**KIRKLEES METROPOLITAN COUNCIL  
INVESTMENT & REGENERATION SERVICE**

**DELEGATED DECISION TO DETERMINE PLANNING APPLICATIONS**

Reference No:	<b>2025/62/92545/W</b>
Site Address:	Stonecourt, Oldfield Road, Honley, Holmfirth, HD9 6NL
Description:	Erection of single and two storey rear extension and associated alterations
Recommending Officer:	Joanna Rednall

**DECISION – REFUSED**

Proposed Block Plan

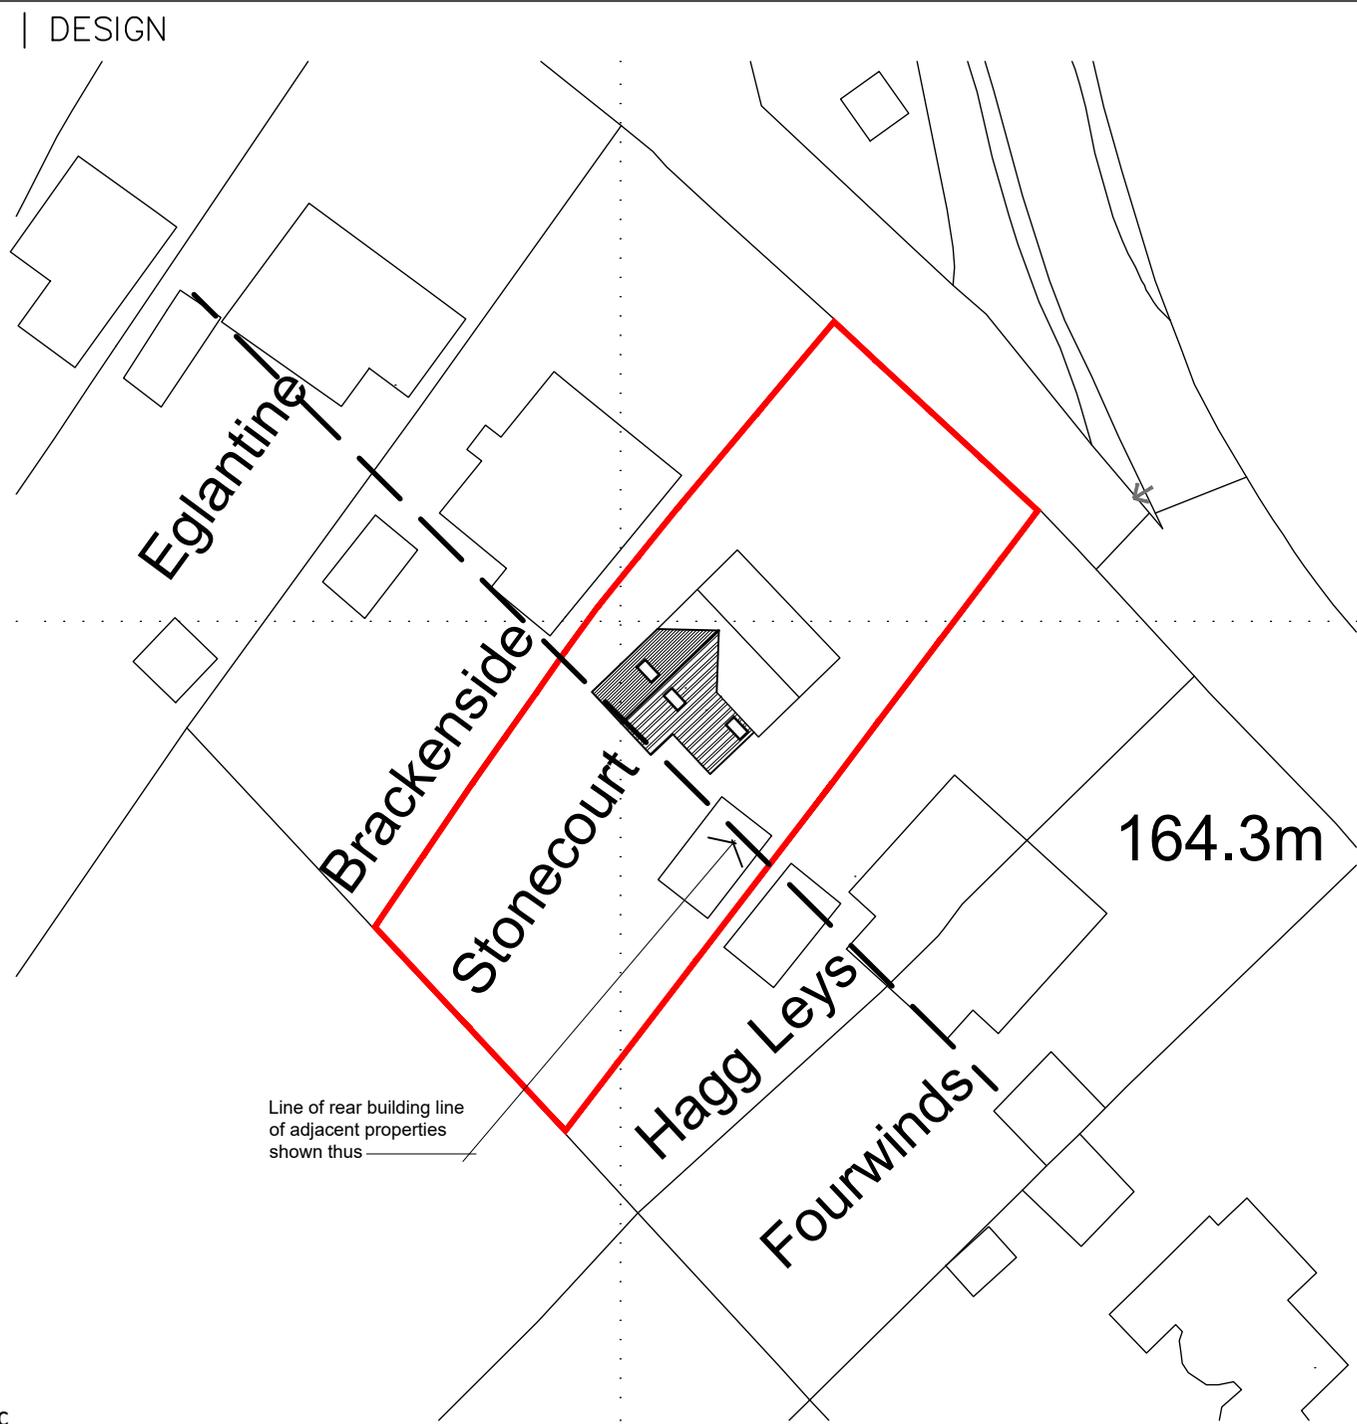
Based on officers volume calculations, the original dwellinghouse had an approximate volume of 485.3m<sup>3</sup>. The proposed extensions, when combined with the existing detached garage, would increase the total built volume by approximately 476m<sup>3</sup>, equating to an overall increase of around 98.1% over the original structure. This represents a substantial intensification of development on the site.

In this instance, it is considered that the proposed single- and two-storey rear extensions, by virtue of their overall size, height, and bulk, would form a visually dominant and discordant addition to the host property. The cumulative massing of the extensions would compete visually with the original dwelling, resulting in a form of development that would fail to appear subservient. The proposal would therefore erode the legibility of the original house as the principal element of the building.

When viewed cumulatively with the existing detached garage, the proposal would materially increase the overall scale and footprint of built development on the site. This additional massing would further compound the visual and spatial impact, resulting in a level of development that is considered disproportionate relative to the size and character of the original dwelling. As such, the proposal would not fall within the exception set out under paragraph 154(c) of the NPPF, which permits extensions to buildings in the Green Belt provided they are not disproportionate additions over and above the size of the original building.

For these reasons, it is concluded that the proposal would amount to a disproportionate addition to the original dwellinghouse, contrary to paragraph 154(c) of the NPPF and Policy LP57(a) of the Local Plan. The development would therefore represent inappropriate development within the Green Belt, resulting in harm to its openness and failing to preserve its character and function.

In addition to the policy conflict identified above, the scale, bulk, and design of the proposed extensions would result in a form of development that appears visually disproportionate and unsympathetic to the proportions of the original dwelling. The extensions, by reason of their size, height, and overall massing, would not read as subordinate additions but rather as competing elements that visually dominate the host building. This lack of subservience conflicts with Key Design Principle 2 of the Council's House Extensions and Alterations SPD, which requires extensions to remain clearly subordinate in scale and form to the original dwelling to ensure visual harmony and coherence.
